Engineers Comments Regarding Surface Water Drainage

Application Reference:	WA/50/25/DOC	Reviewer Reference:	ADC/EXT4
Planning Officer:	Amber Willard	Date of Review:	11/12/202
Site Name:	Fleurie Nursery Lake Lane Barnham PO22 0AL		
Application Description:	Approval of details reserved by condition imposed under reference WA/75/20/PL relating to condition number 3 - surface water drainage scheme, condition number 4 - surface water drainage system and condition number 7 - surface water drainage scheme.		
Assessment Number:	2 of 2

Outfall A (North)

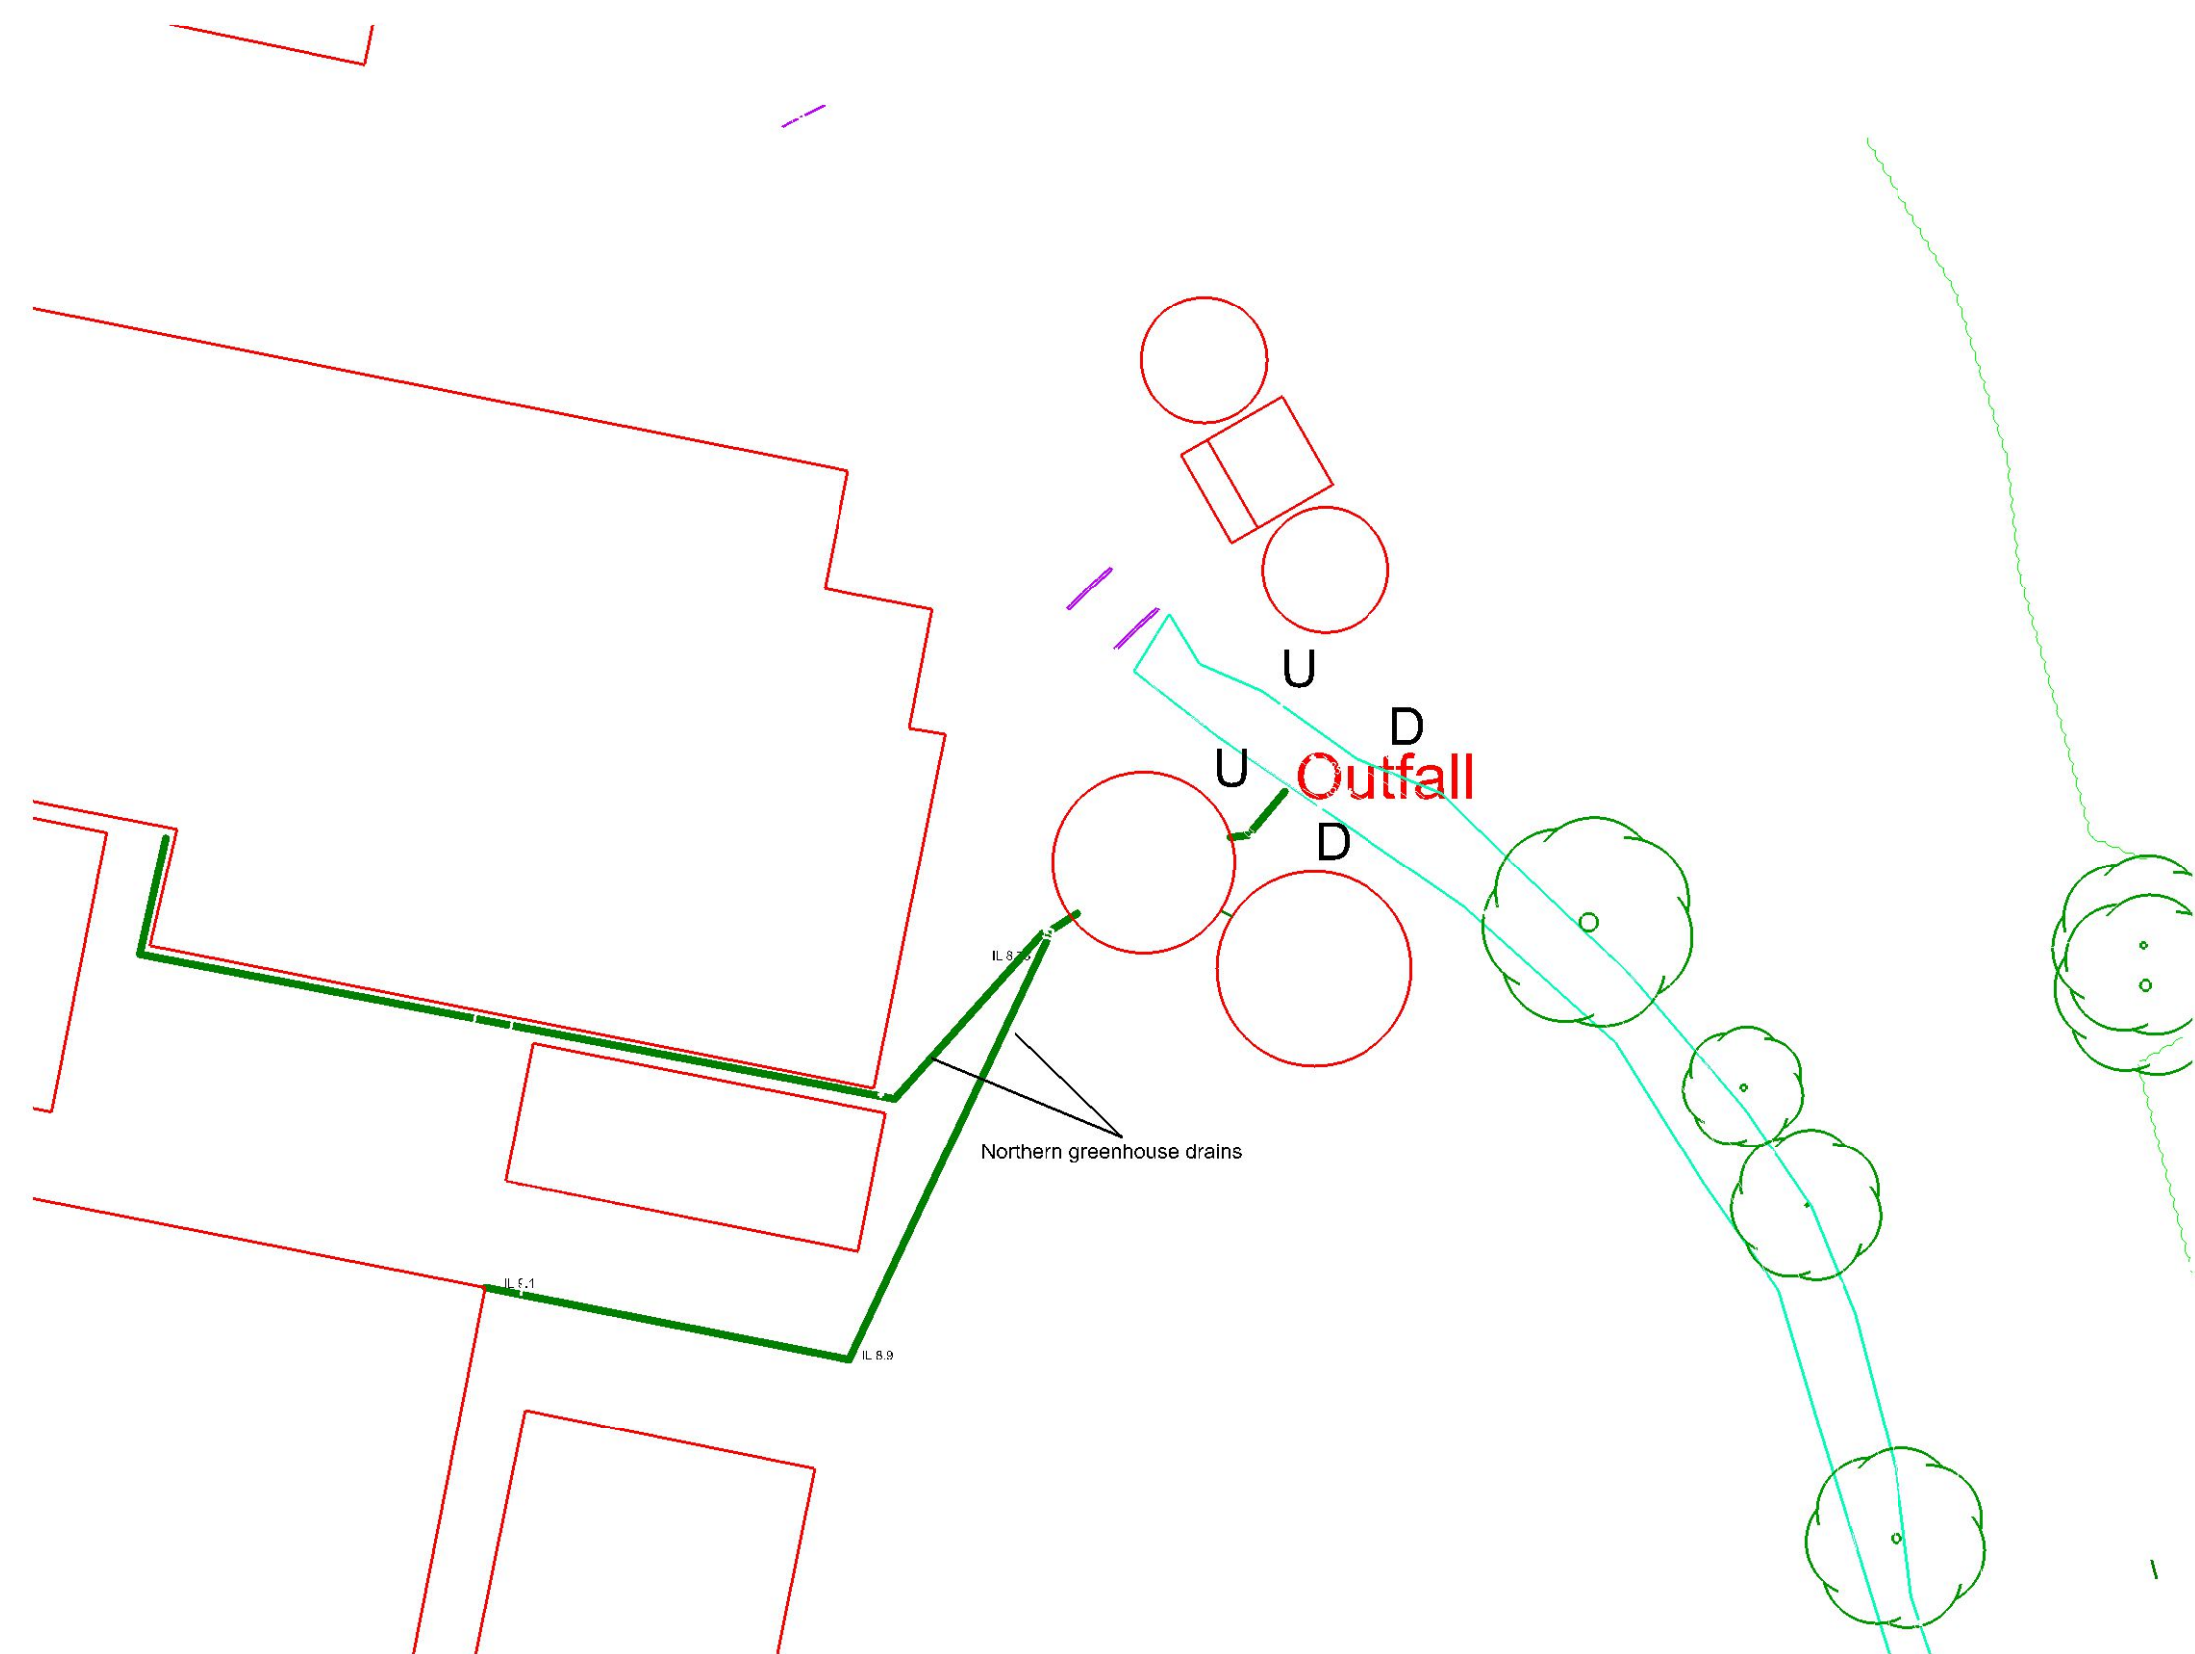
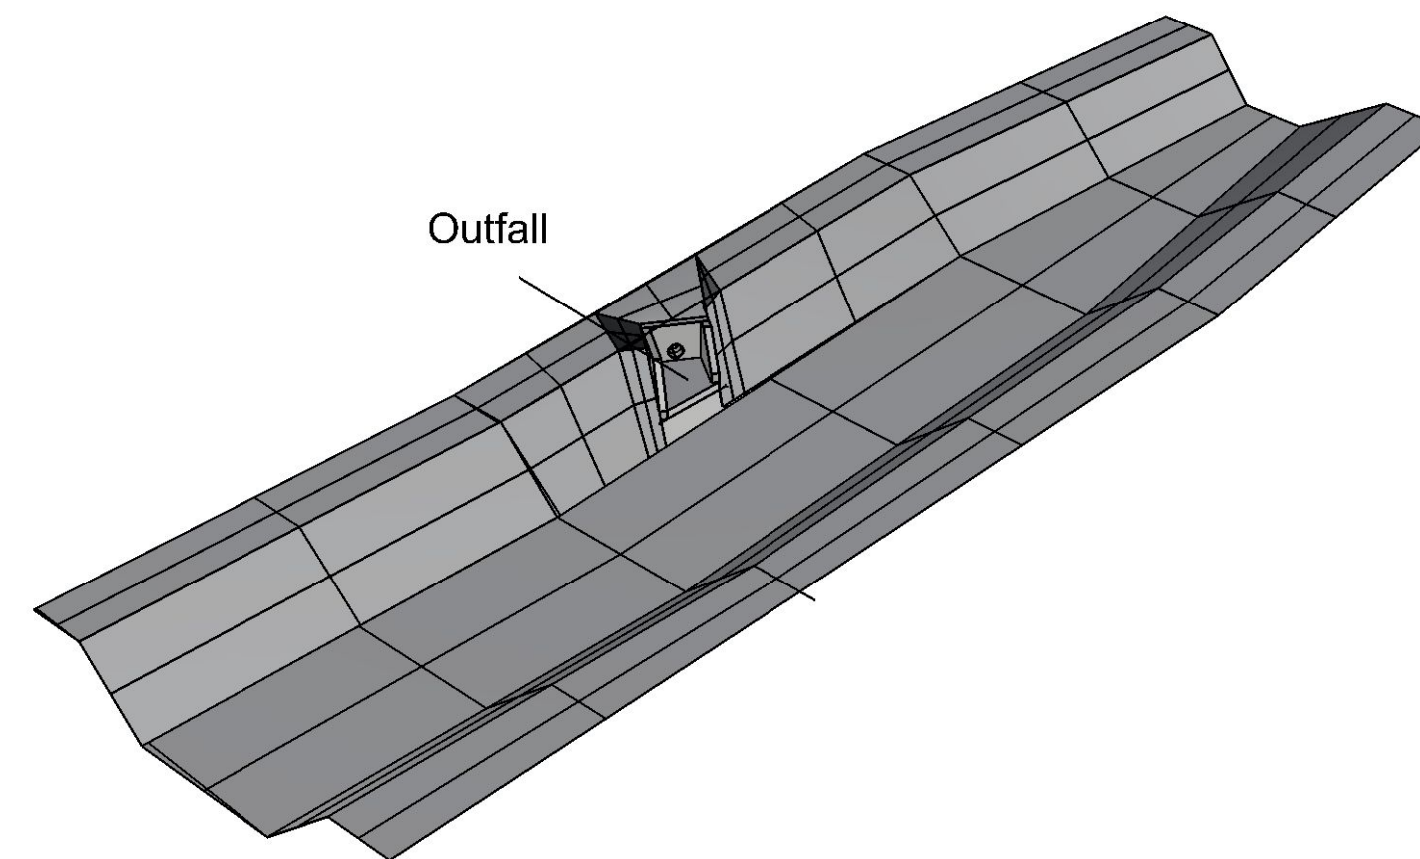
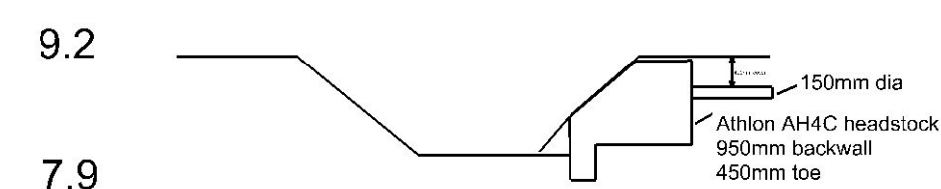
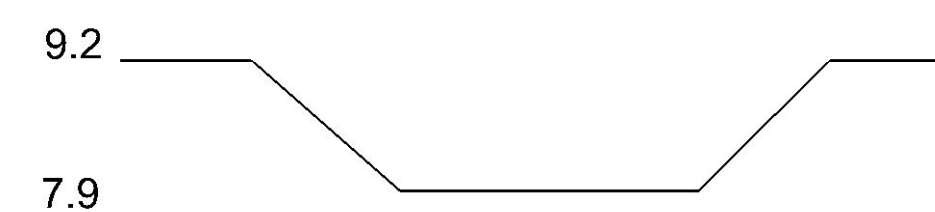
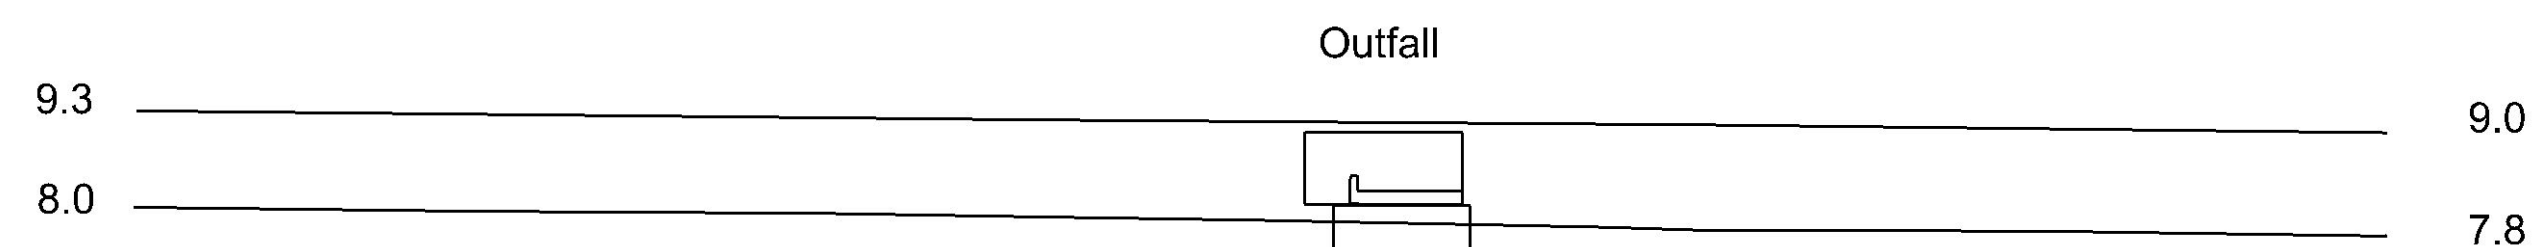
6.	The headwall outfall details provided are insufficient and do not provide any construction details on specific type of headwall, bedding details, interface with the existing earthworks etc..	Construction details for the headwall as agreed as part of the Ordinary Discharge Consent are enclosed, see drawings "Outfall North", "Outfall South", "Outfall construction v2" and also "Construction Notes".	Thank you noted and closed		
7	Please provide details on existing trees and any proposed planting to ensure that the proposed drainage does not conflict with existing//proposed planting	There are no trees on site that are close enough to be relevant to this proposal.	From review of satellite images there appears to be trees along the watercourse as well as northern side of Lake Lane which potential proposals could impact with existing trees or their respective root protection areas. Please provide a clear topographic survey clearly identifying existing trees and overlay with the drainage proposal
